Recommendation Report for Planning Permission for Works or Extension to a Dwelling

REF NO: WA/28/22/HH

LOCATION: Brooklands
6 Burch Grove
Walberton
BN18 0BB

PROPOSAL: Loft conversion with hip to gable roof, rear dormer window and two front Velux windows.

ELEV PLAN

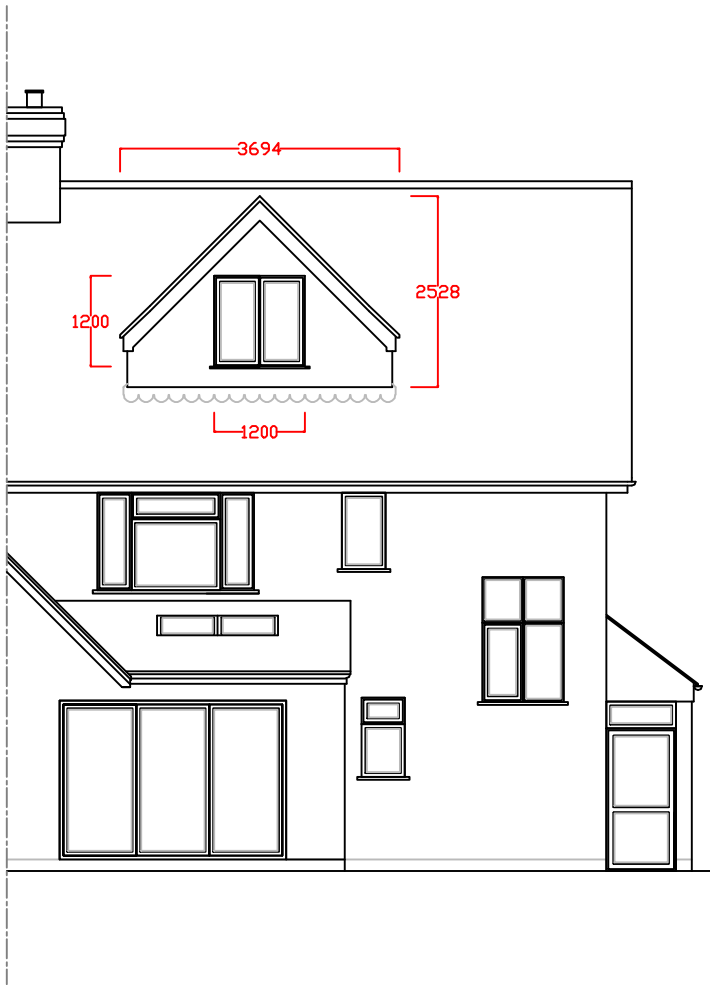
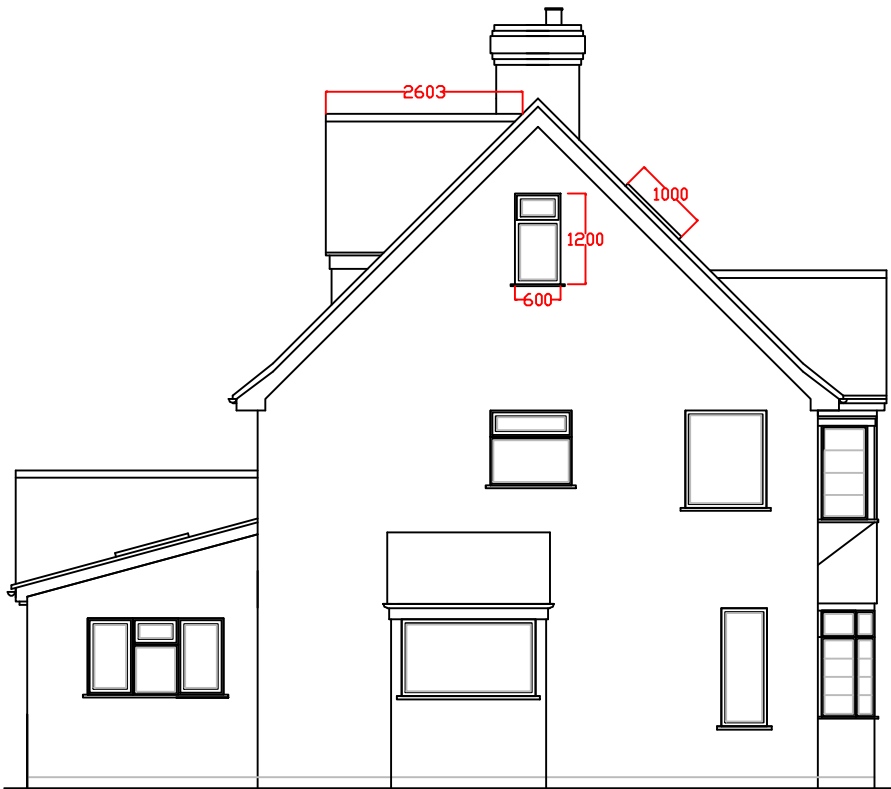
The proposal has a hipped roof which will alter to form a gable end. The neighbouring attached dwelling matches in appearance and the hip to gable alteration will result in the dwelling differing in appearance. The surrounding properties have gable ends and the alteration will not result in the property appearing out of character with the surrounding area.

A dormer is also proposed although this is not visible from the wider area, located to the rear elevation.

The Arun Design Guide states 'Dormers should be a minor incident in the roof plane and made of sympathetic to the existing or original building materials,' Are located symmetrically and centrally on a roof, without being overly dominant or out of proportion and/or style to the original structure.' 'Favours small scale dormer windows with pitched roofs over large, flat box-shaped designs'. The proposal complies with the design guide in that the dormer is well designed consisting of a pitched roof that is appropriate in scale on the roof slope.

The hip to gable is located to the eastern elevation. There are no neighbours to this elevation and as such it will not result in adverse overbearing or overshadowing.

The dormer to the rear will have a length of 3.45m, a depth of 2.55m and a height of 2.45m. This has a pitched roof. This occupies a modest amount of the roof slope and retains approximately 1.6m to the boundary. Due to its size and siting, this will not give rise to overbearing or overshadowing upon amenity.

The dormer will have 1 window. This will give rise to some additional views over the neighbouring garden to the west which are not currently achievable although when looking at a 45 degree angle, views are limited and will not be direct into windows. There are no properties directly to the rear or east. Dormers can also be permitted development in some cases.

A second floor window is also proposed to the gable end. With no neighbours to this elevation, it will not result in adverse overlooking.
